From: Andrew Wood
Sent: 06 March 2019 12:13
To: Planning.Responses
Subject: FW: Wicks Farm, Ford - F/30/18/PL

Please see below the email response from CEP to the comments made by the ADC Drainage Consultee concerning the planned reservoir at Wicks Farm, Ford.

From: Martin Kempshall 
Sent: 01 March 2019 14:33
To: John Hall 
Cc: CEP | Reception ; Steve Burgess 
Subject: 22979 - Wicks Farm, Yapton

Drawing Title
Proposed Drainage Layout

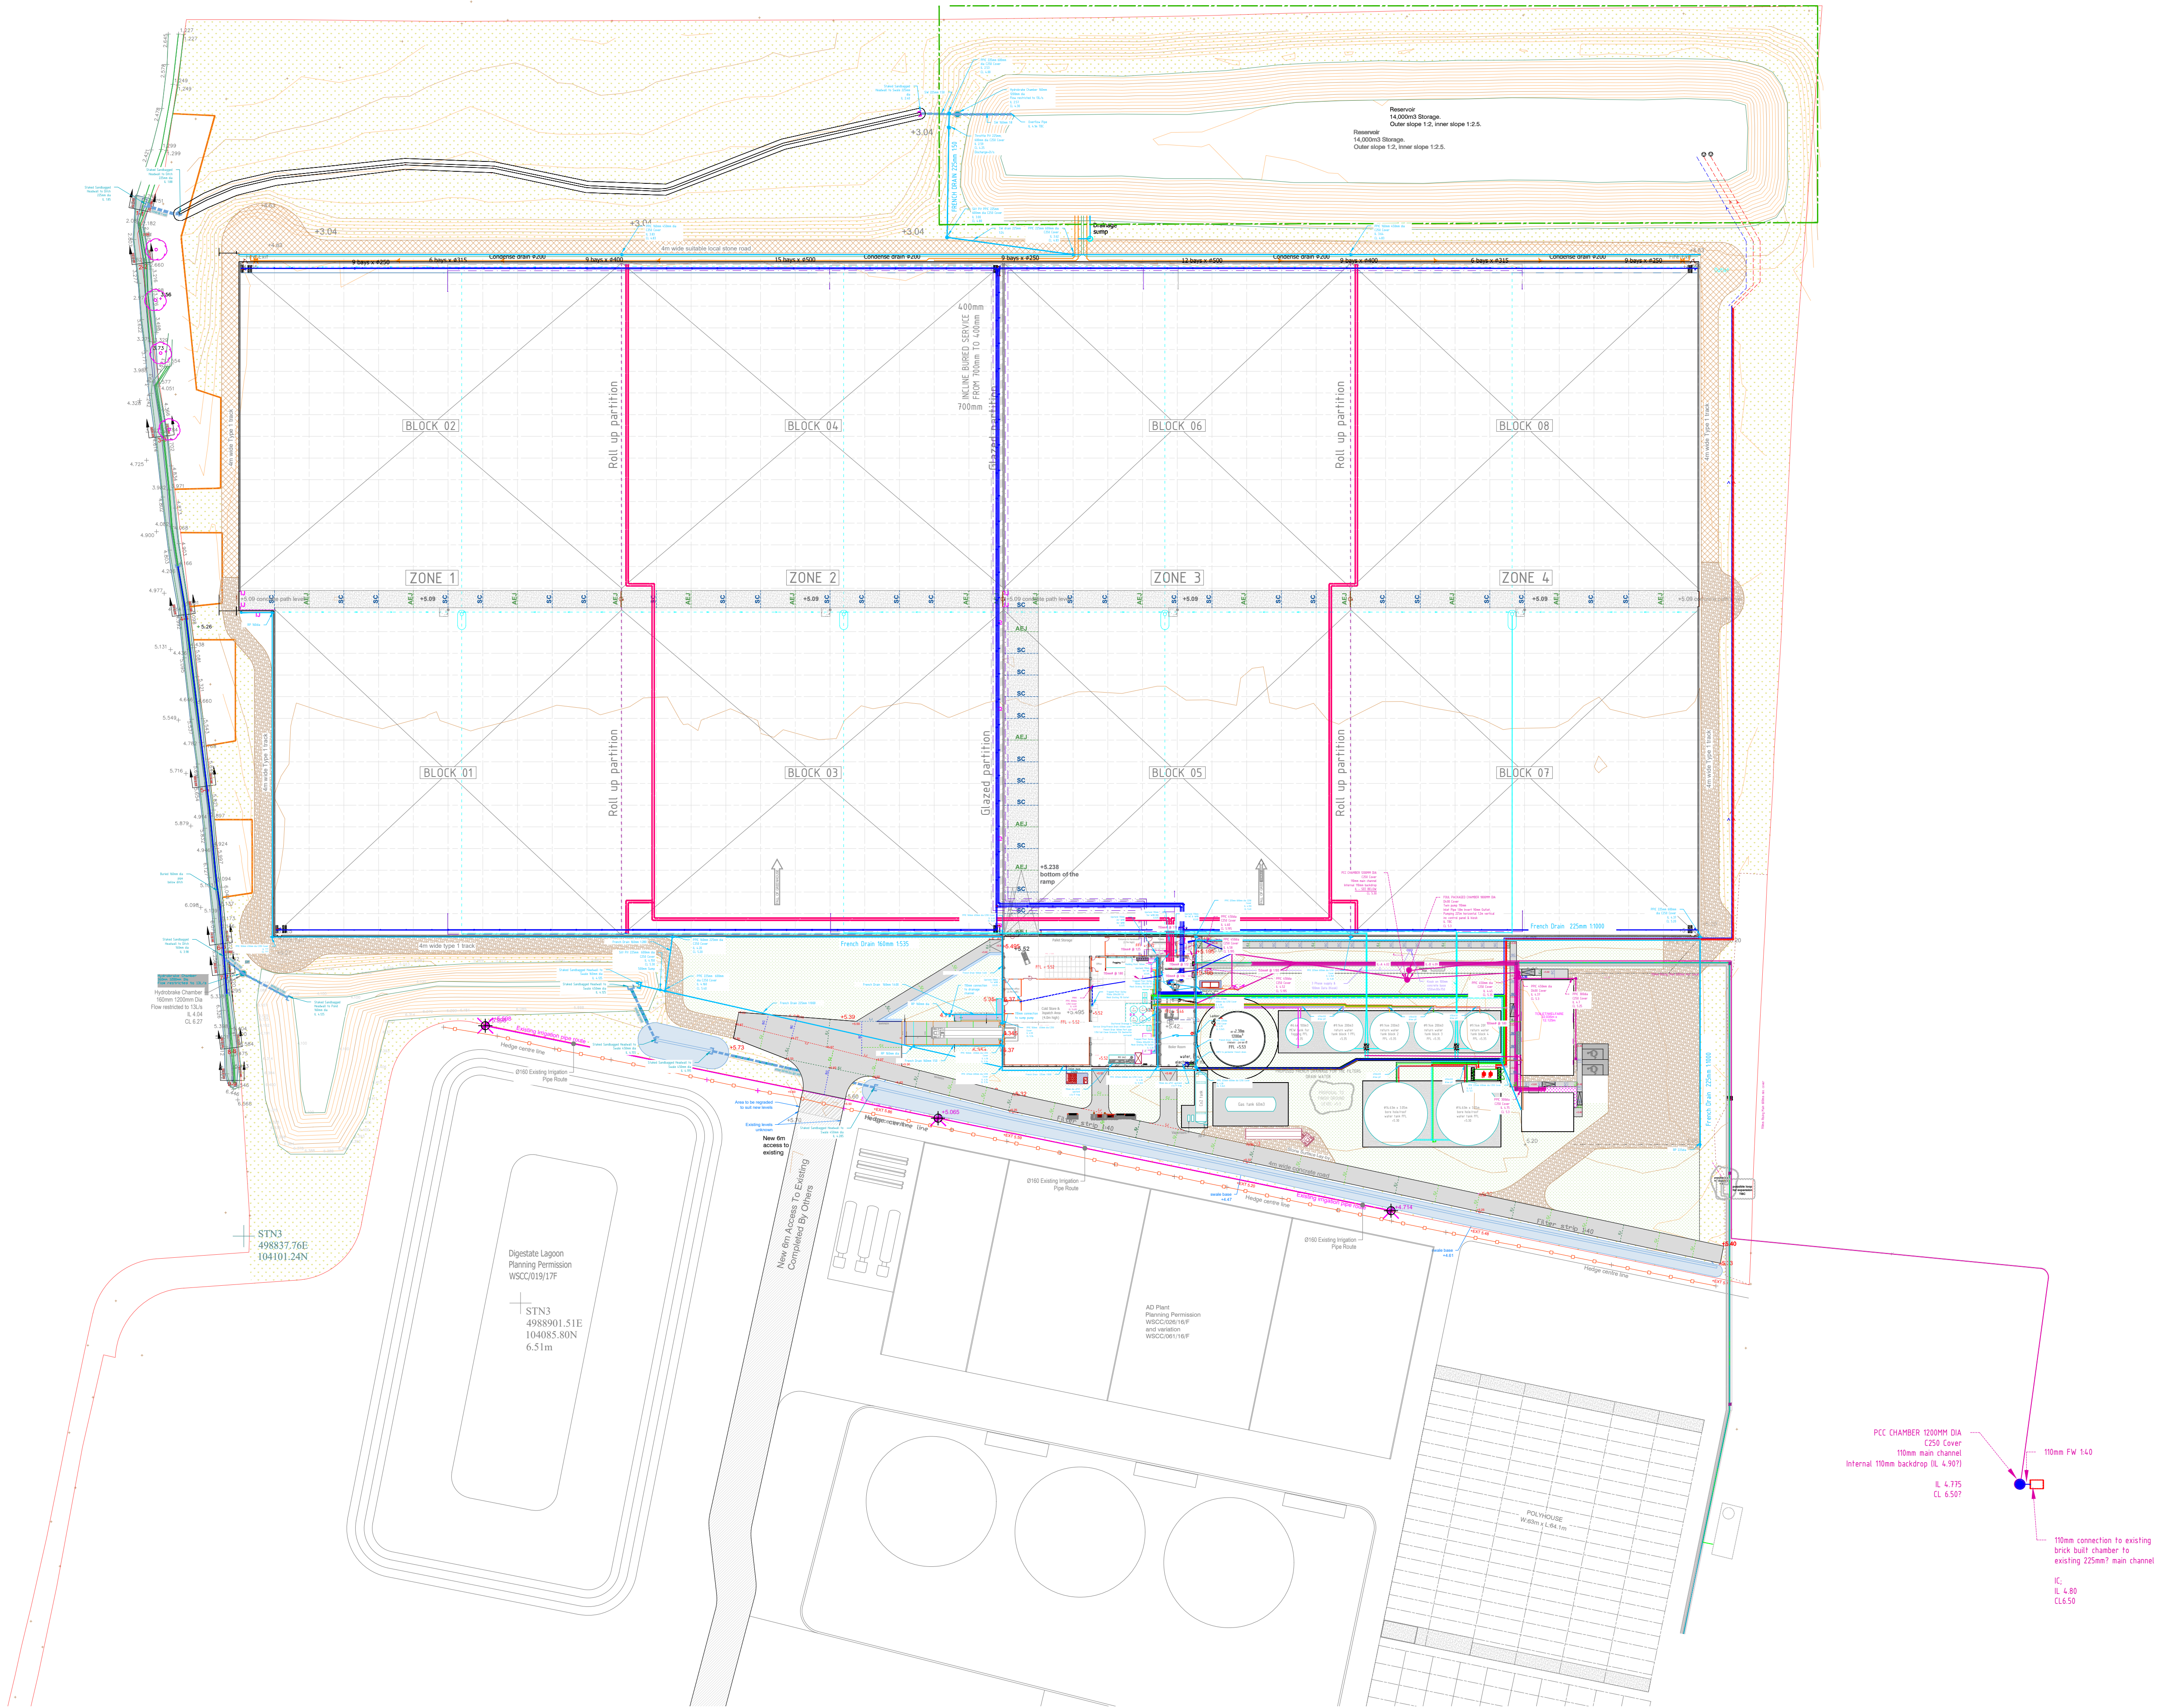
The request for infiltration to ground is based upon the SuDS hierarchy where this is always the first preference. However, I would argue this is inappropriate in this case as typically it would be preferential to lined the reservoir to maintain summer level during peak water usage, this can be proposed as part of the final design.

With regard to the comment on winter storage, winter irrigation usage could be considered within calculations as part of the detailed design to demonstrate that sufficient capacity could be maintained within the reservoir during the winter months. In the event that the reservoir was not capable of storing sufficient runoff for the design event during the winter months it could be demonstrated that any overland flow would follow existing land drainage flow paths. As a fall-back position, a mechanism or procedure could be in place to drawdown some of the lagoon to provide capacity before a forecasted major rainfall event.
